CITY OF ALBUQUERQUE

Re: Westside Skate Park Phase 1, 6900 Gonzales Road SW, Site Development Plan

Engineer's Stamp dated 8-08-05 (L10-D13A)

Based upon the information provided in your submittal received 8-08-05, the above referenced plan is approved for Paving Permit and Grading Permit. Upon completion of the project, please provide an Engineer Certification for our files.

Sheet **6** Of **12**

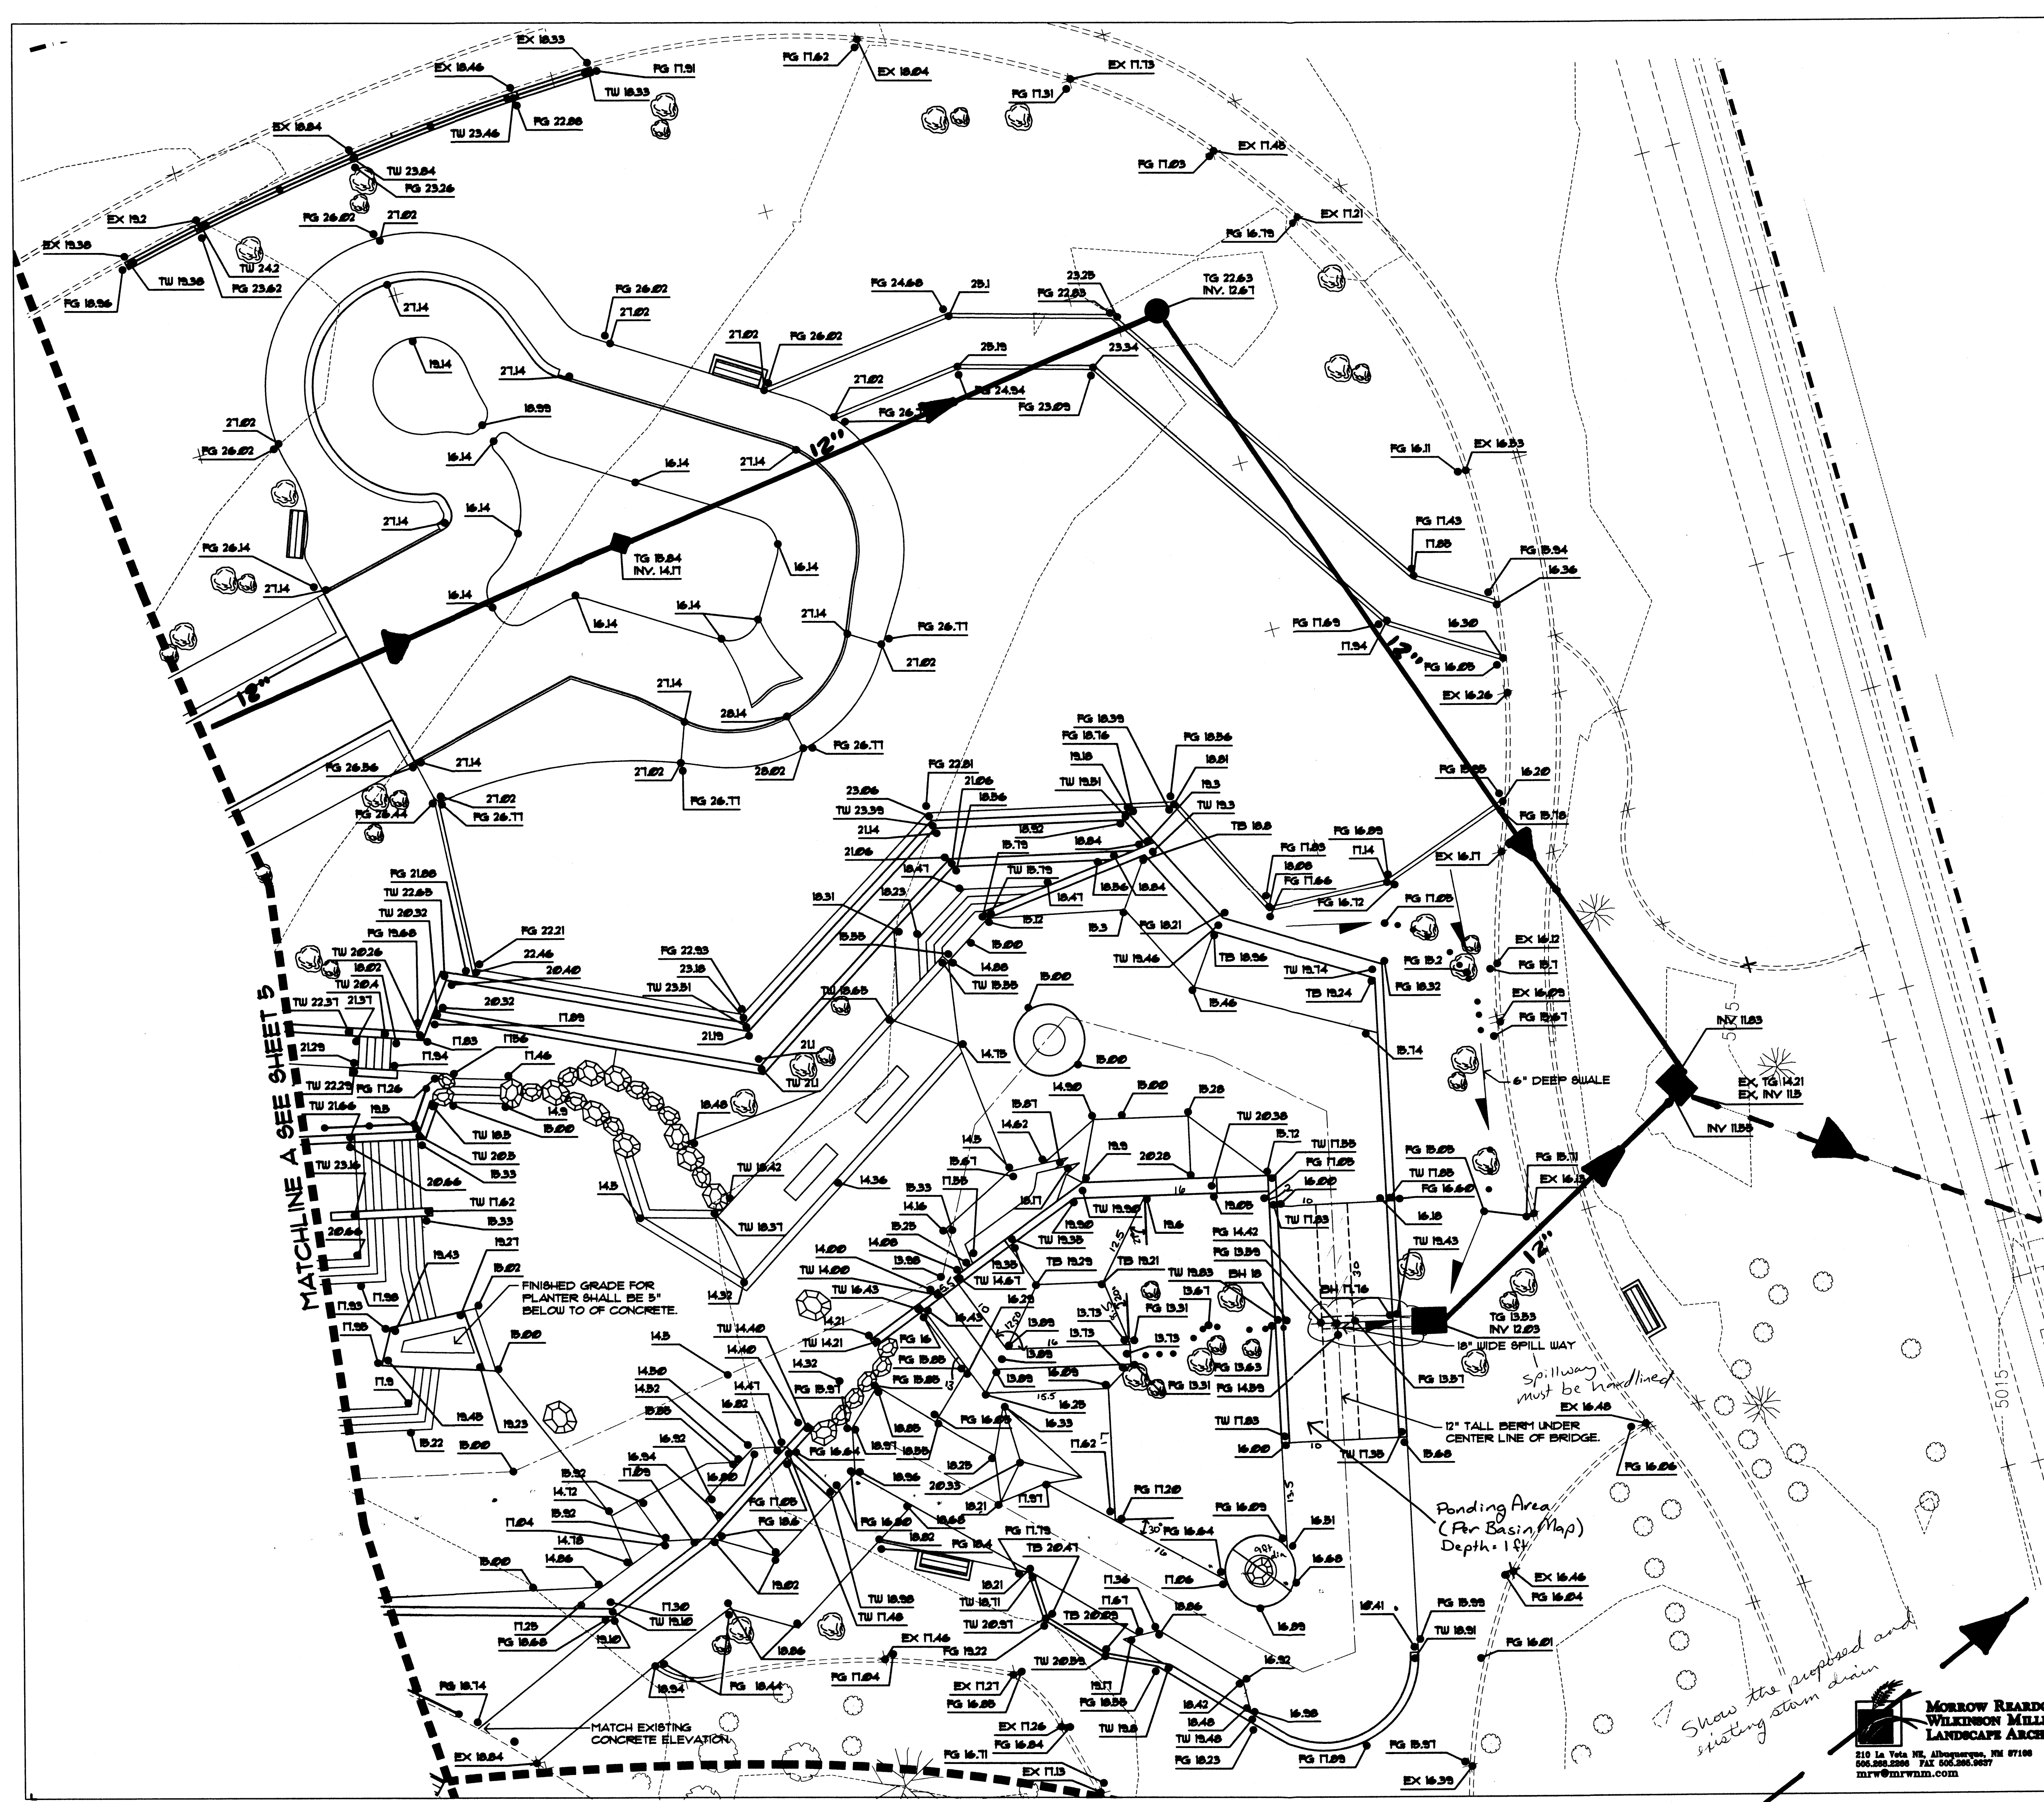
Still not shown on grading plan

1. The 18" wide spillway must be hardlined.
2. Show the proposed and existing storm drain, along with associated inverts, on the grading plan (sheets 5 and 6).
3. Clearly indicate the ponding area on the grading plan (sheet 6).

Response: Concur; the proposed and existing storm drain has been included on the grading plan. Inverts have been provided.

DRAINAGE REPORT

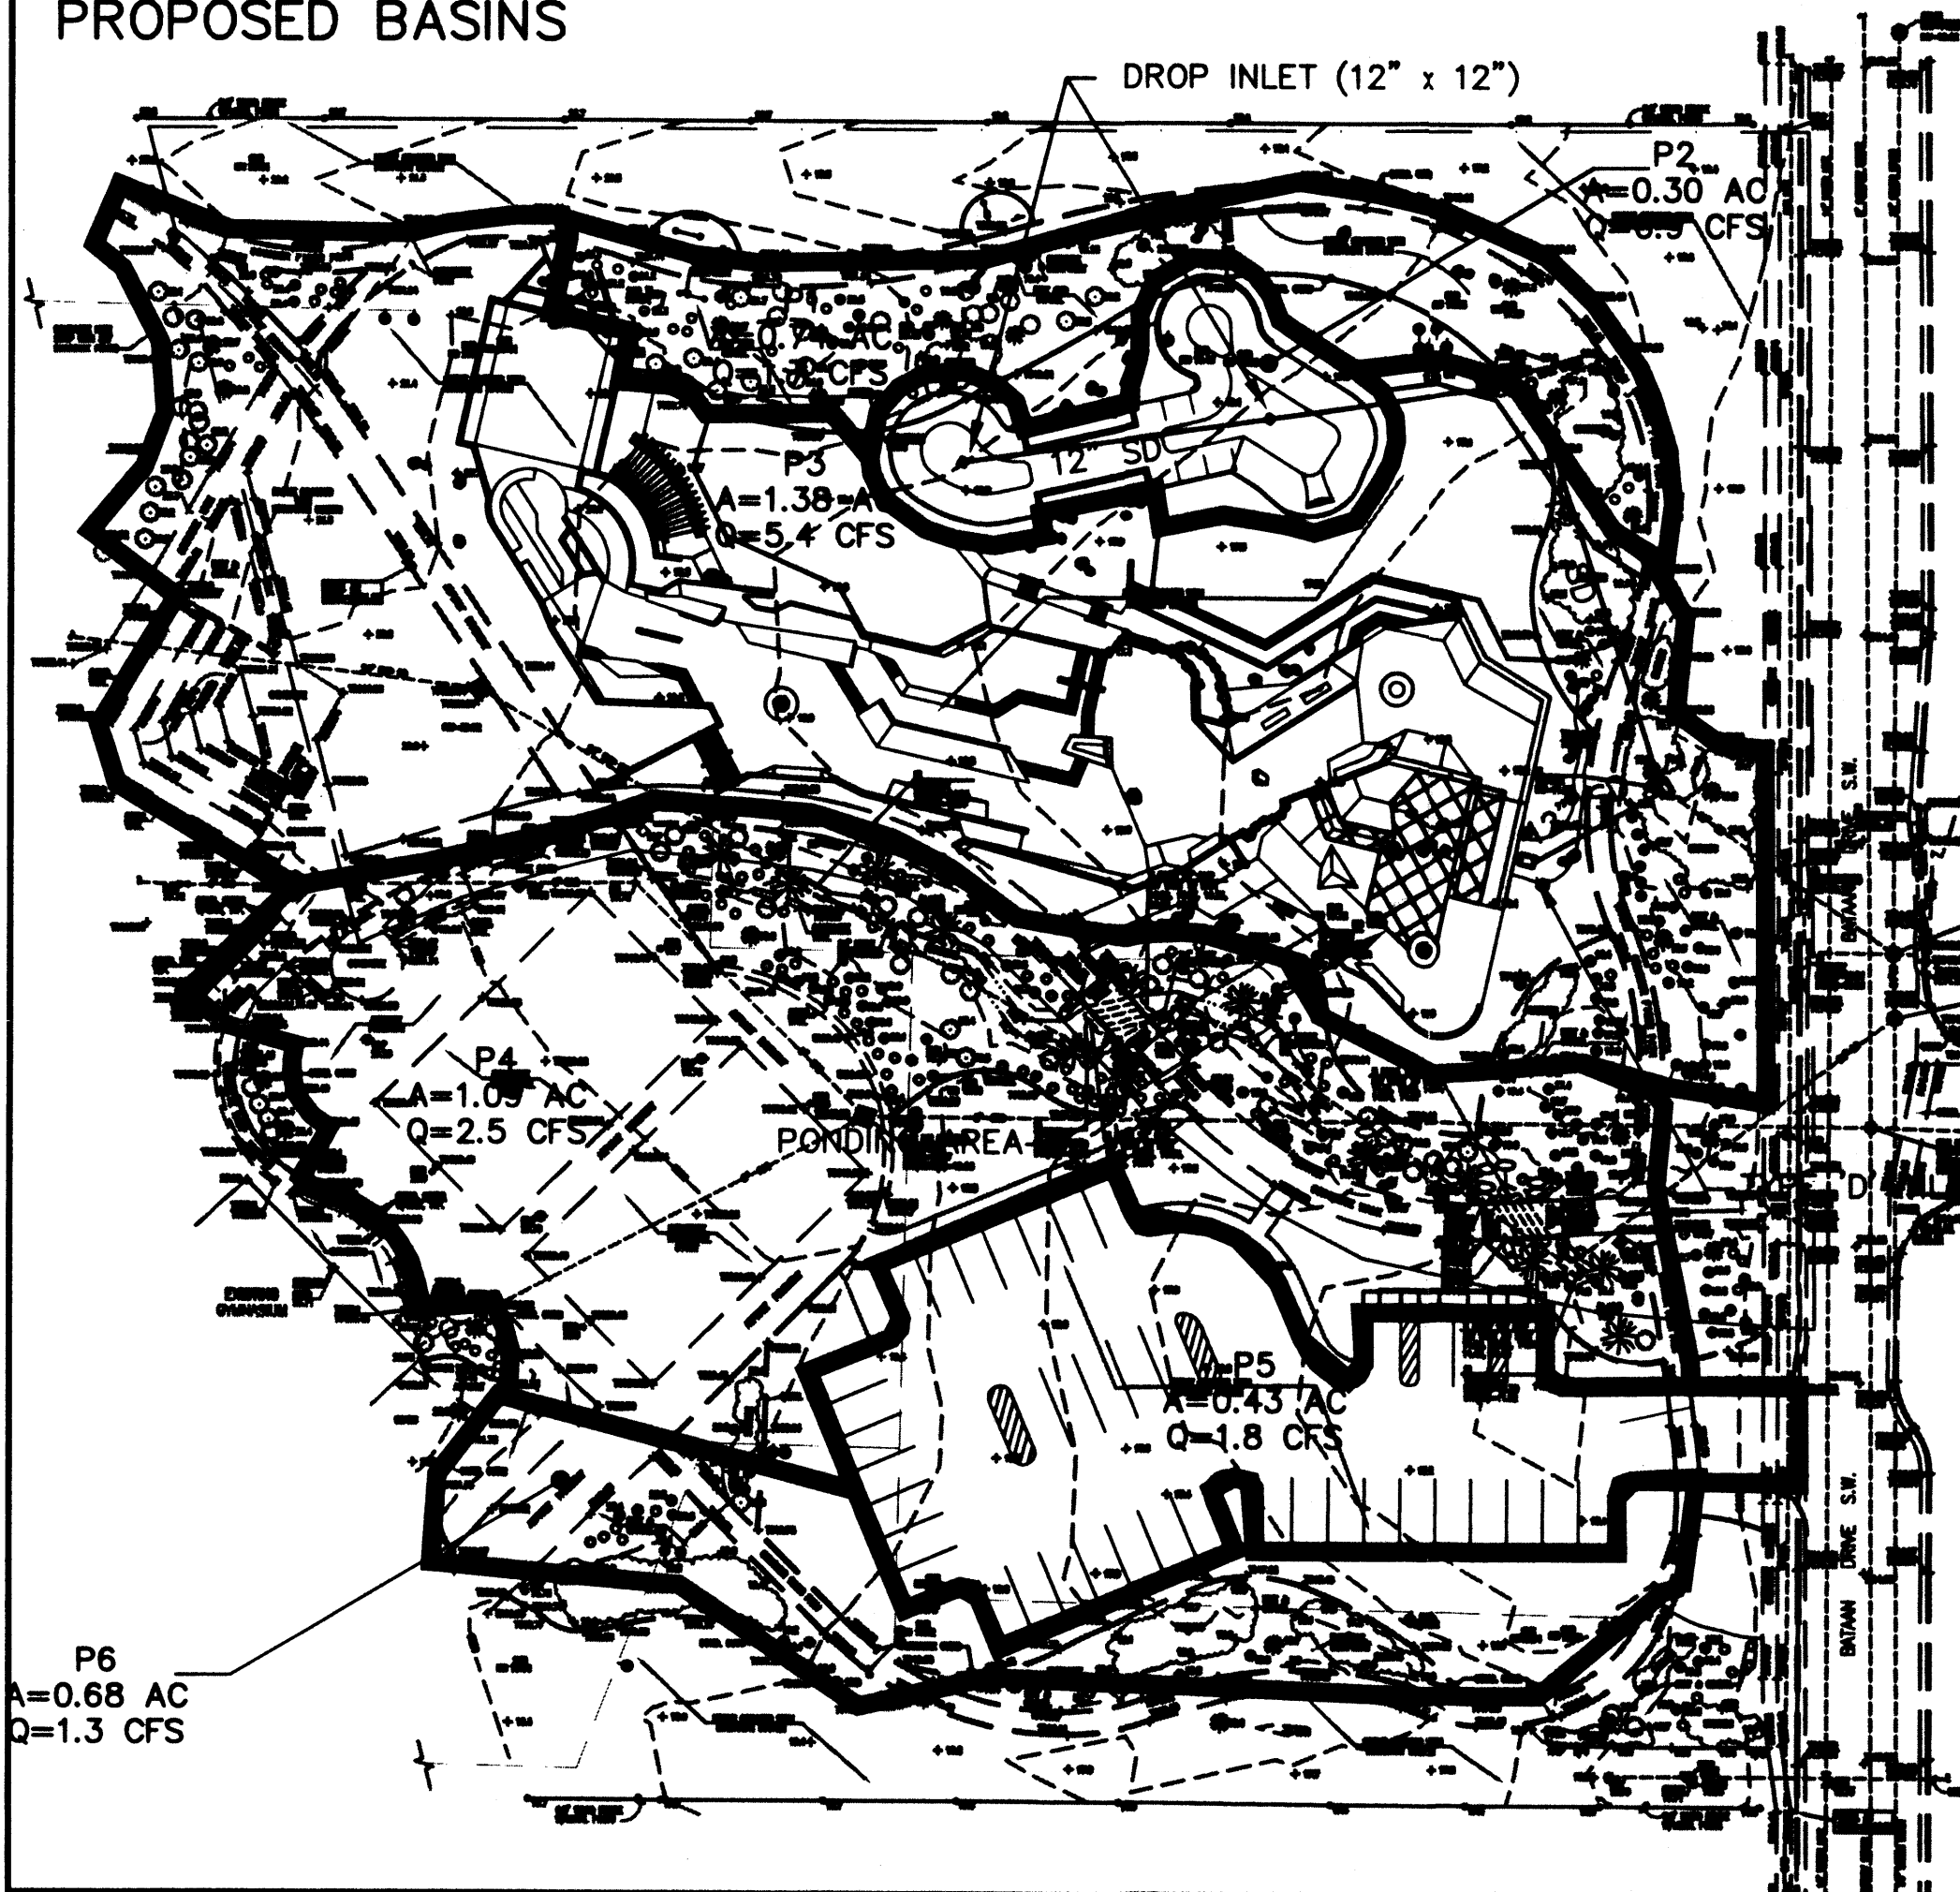
Comment 2. *Why is your pond outfall an earthen berm with a 2" invert? Provide the weir equation.*

Why not calculating
for a broad weir?
According to plan,

↑
How did they determine
 $C_d = 3.0$?

Response: The grate inlet capturing flows from Basin P3 is located in a landscaped area. The 12" earthen berm was selected to detain flows upstream of the landscaping features, in an effort to minimize any deposition on these features. The engineer's rationale was that an orifice plate would concentrate ponding and deposition in an area that is readily visible. The berm, on the other hand, is underneath the pedestrian bridge, such that most deposition would be in an obscured location, thus preserving the aesthetic qualities at the site. Flows were modeled as a trapezoidal (Cipoletti) weir using FlowMaster software. Output from this software is provided in this submittal. The general equation for a broad-crested weir has been provided in the drainage report.
